In reply please quote: 12/02624

HORSLEY DRIVE BUSINESS PARK – SSD 5169 – PUBLIC EXHIBITION OF STATE SIGNIFICANT DEVELOPMENT

I refer to correspondence from the Department dated 6 July 2012 regarding public exhibition of the abovementioned proposal. I advise that Council at its meeting of the 21 August 2012 endorsed the following submission to the proposal.

SECTION AA - Entry
1:200

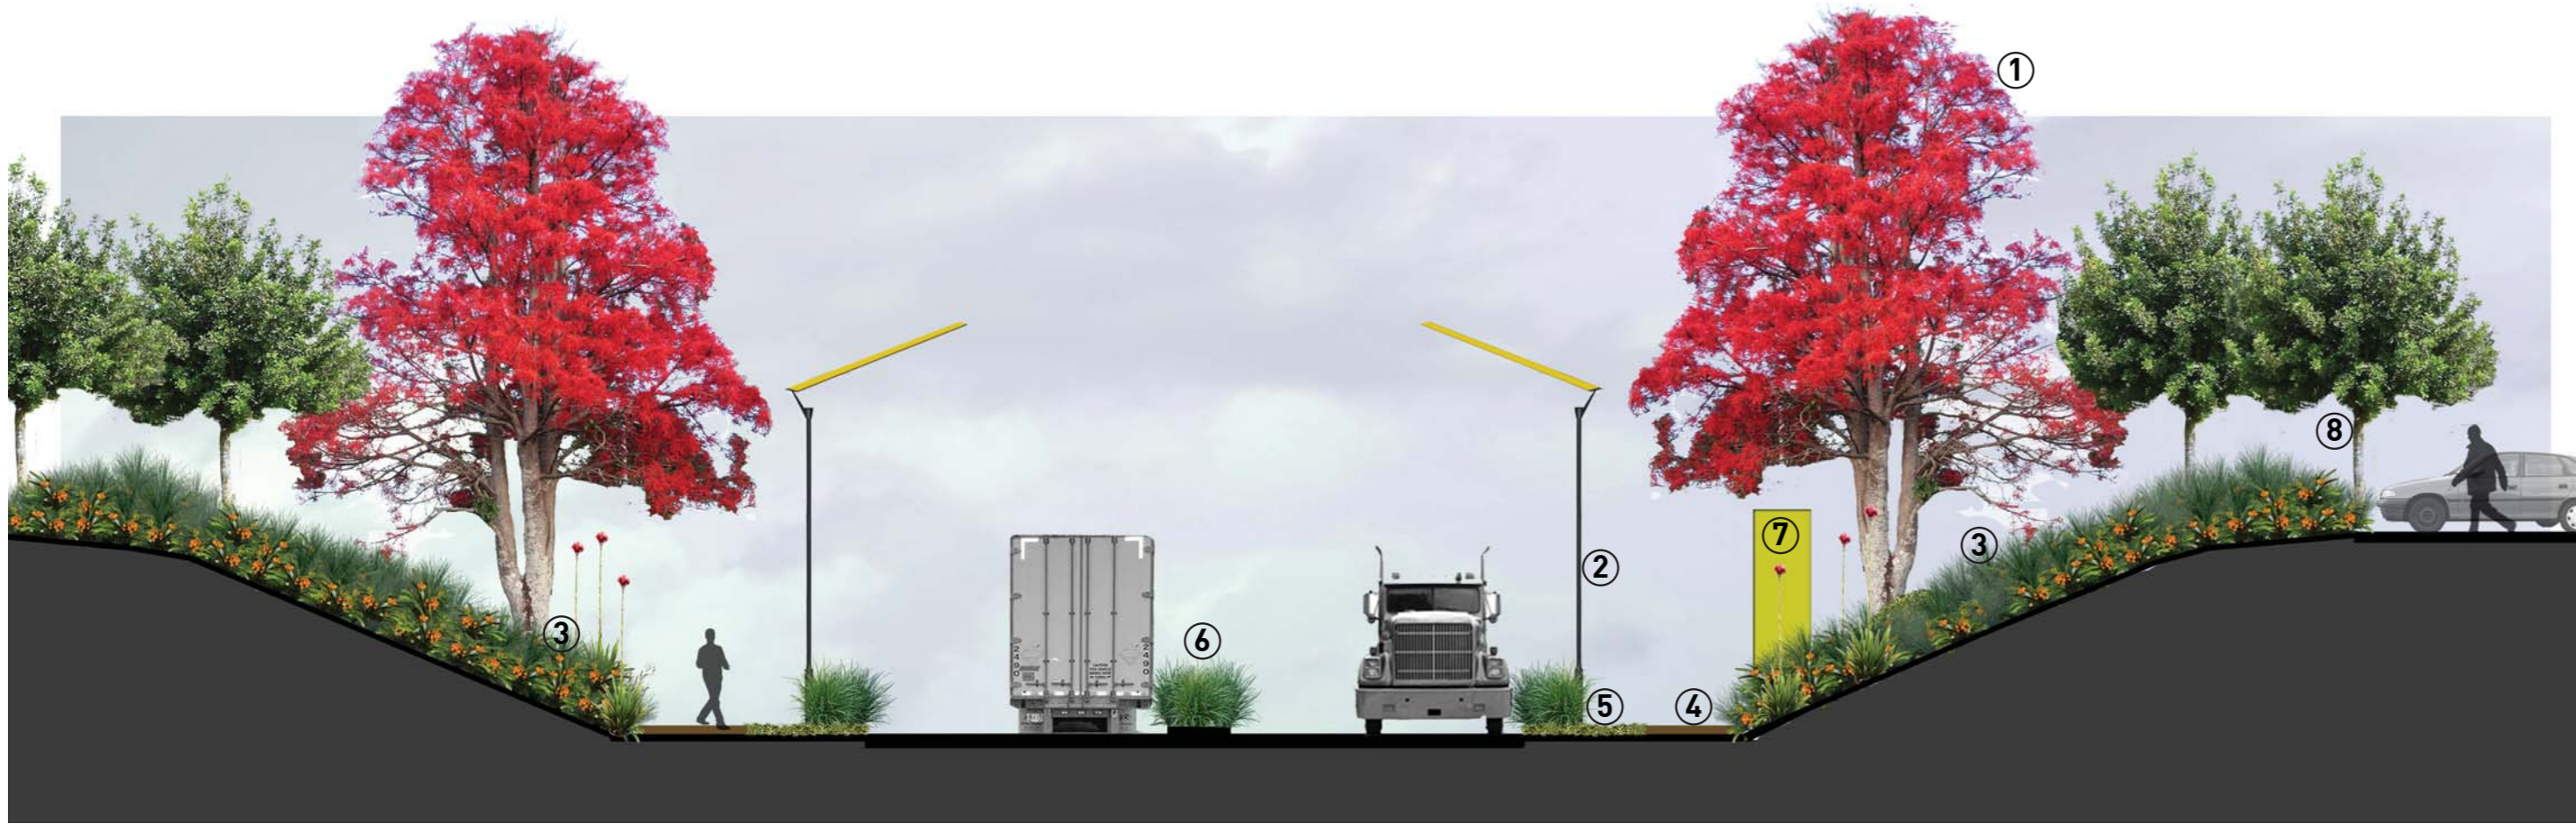
The development will have an adverse impact on the setting of the item. This would be ameliorated by the proposed 20m landscaped buffer (see comments under setbacks above) along The Horsley Drive. In addition to the above, the tree provides an important landscape component to the gateway signage feature constructed by Council at this location.

SECTION CC - Horsley Road
1:200

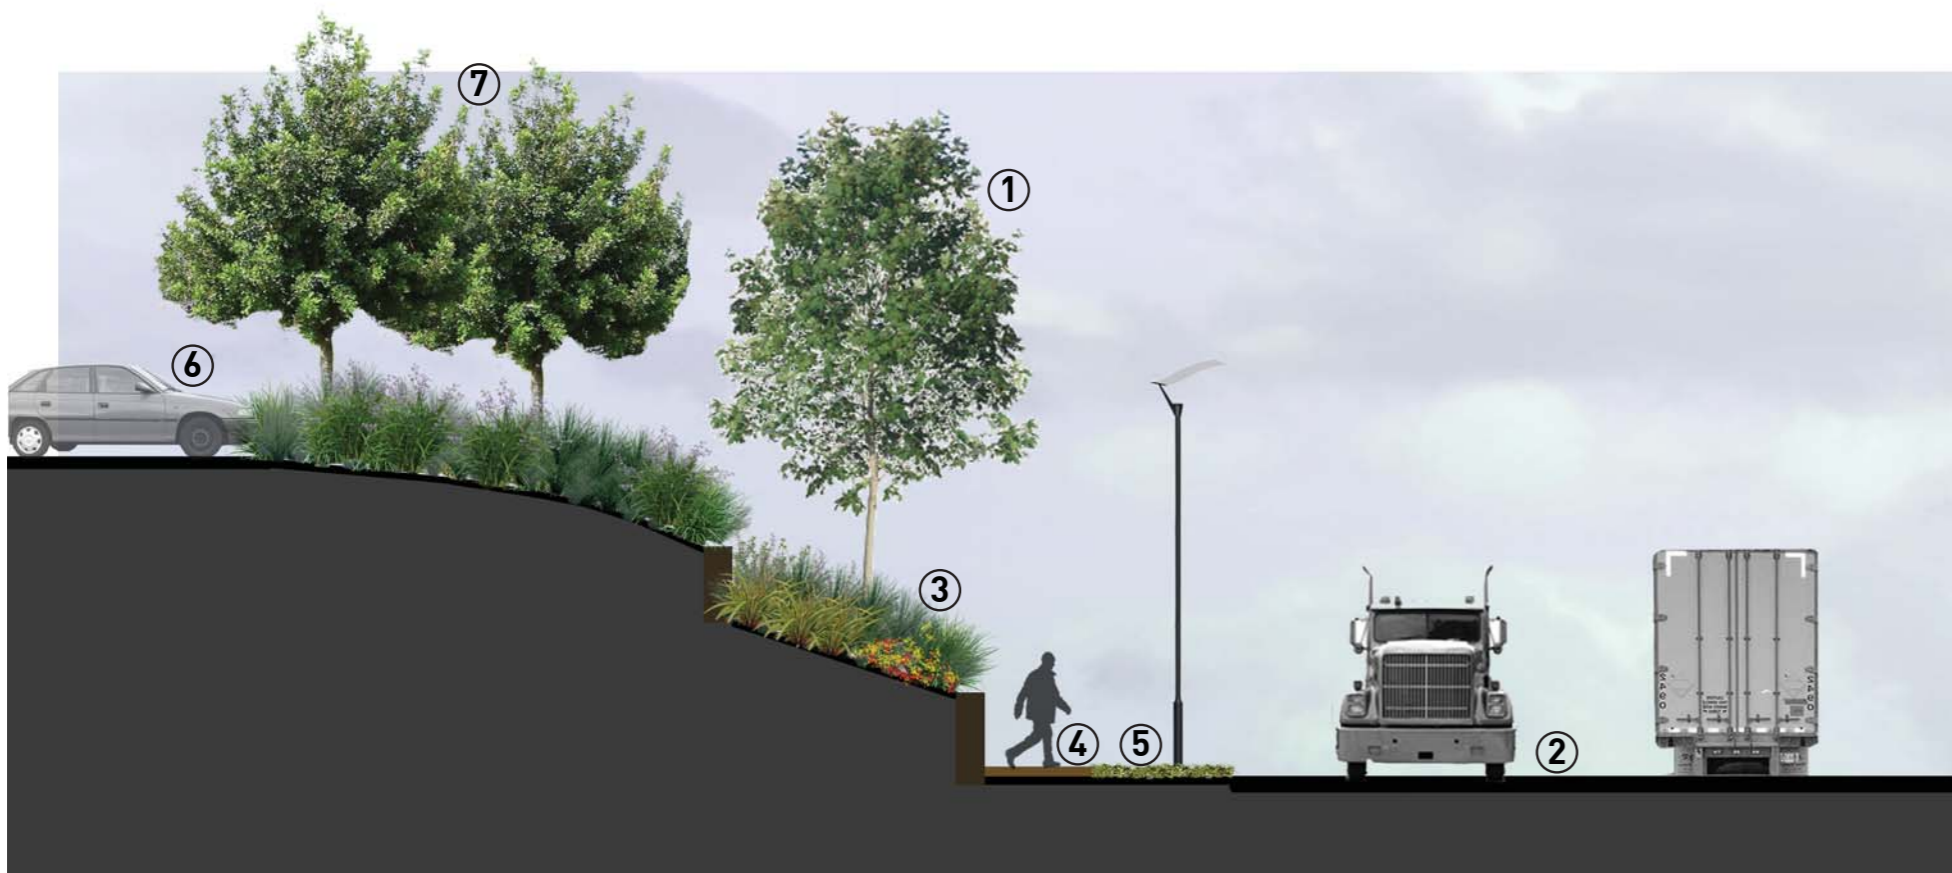
Plans submitted for the proposal indicate a proposed setback for the development ranging from approximately 10 – 14 metres along The Horsley Drive and Cowpasture Road. In addition, future industrial development along

The Horsley Drive would be located on elevated 'pads' positioned approximately 3m above the roadway.

These arrangements are considered inadequate given the gateway and landscaped character of the area.

Under Council's City Wide DCP a minimum setback requirement of 20 metres applies to industrial development along The Horsley Drive. Of this area, 10m needs to be landscaping with the remaining 10m being available for car parking.

To soften the visual impact of future industrial development, it is recommended a full 20m landscaped setback be applied along entire frontage of the site to The Horsley Drive being the principle western entrance into Wetherill Park. This frontage also has a strong visual relationship with the Parkland area to the south. To achieve this setback there is scope to reduce setbacks along the internal access roads.

5. *That a minimum landscape setback of 20 metres be provided to The Horsley Drive frontage of the site. A 20 metre buffer also to be provided along the western and northern boundaries of the site some of which may be incorporated within the Parklands.*
